YorkshireWater

Your Ref: 2016/0076
Our Ref: S002628

Land at Newsome Avenue Wombwell Barnsley - Residential development of 14 dwellings and associated works

Title :  
Planning Layout

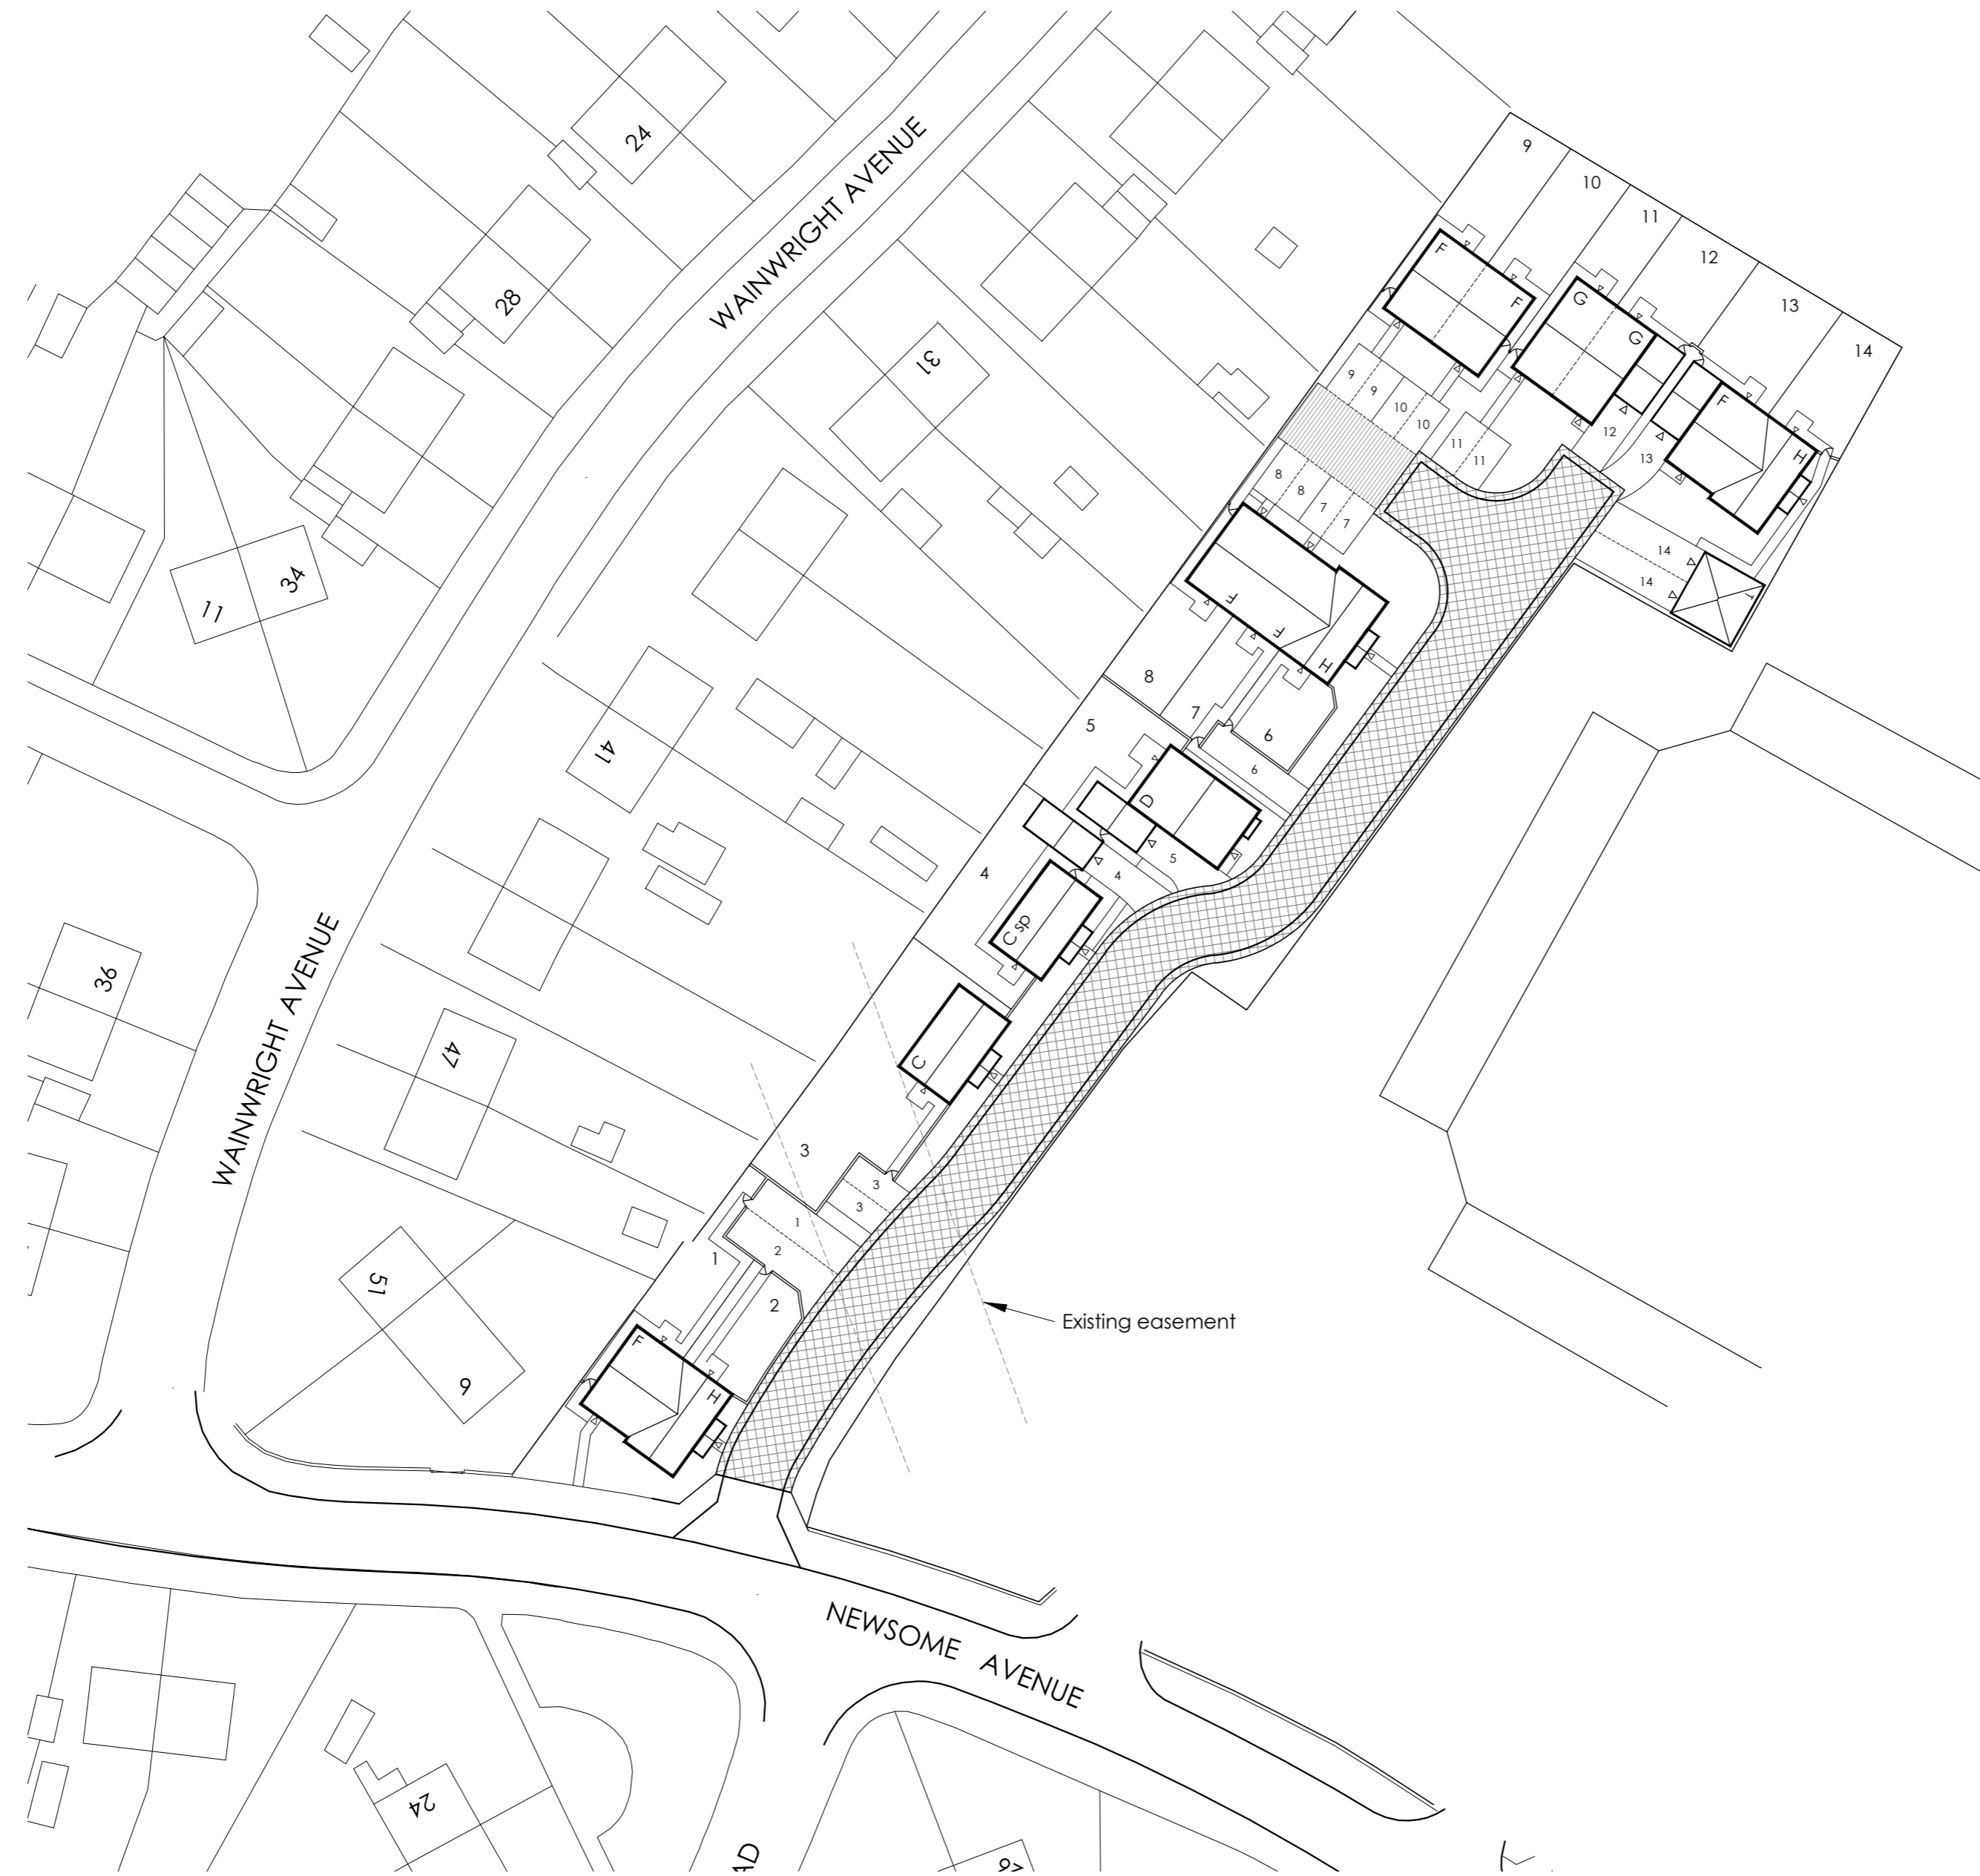
LAYOUT - On the Statutory Sewer Map, there are existing public sewer a recorded to cross the red line site boundary. A stand-off distance of 3 (three) metres is required at each side of the sewer centre-line. In this instance, Yorkshire Water has no objection to the proposed building layout.
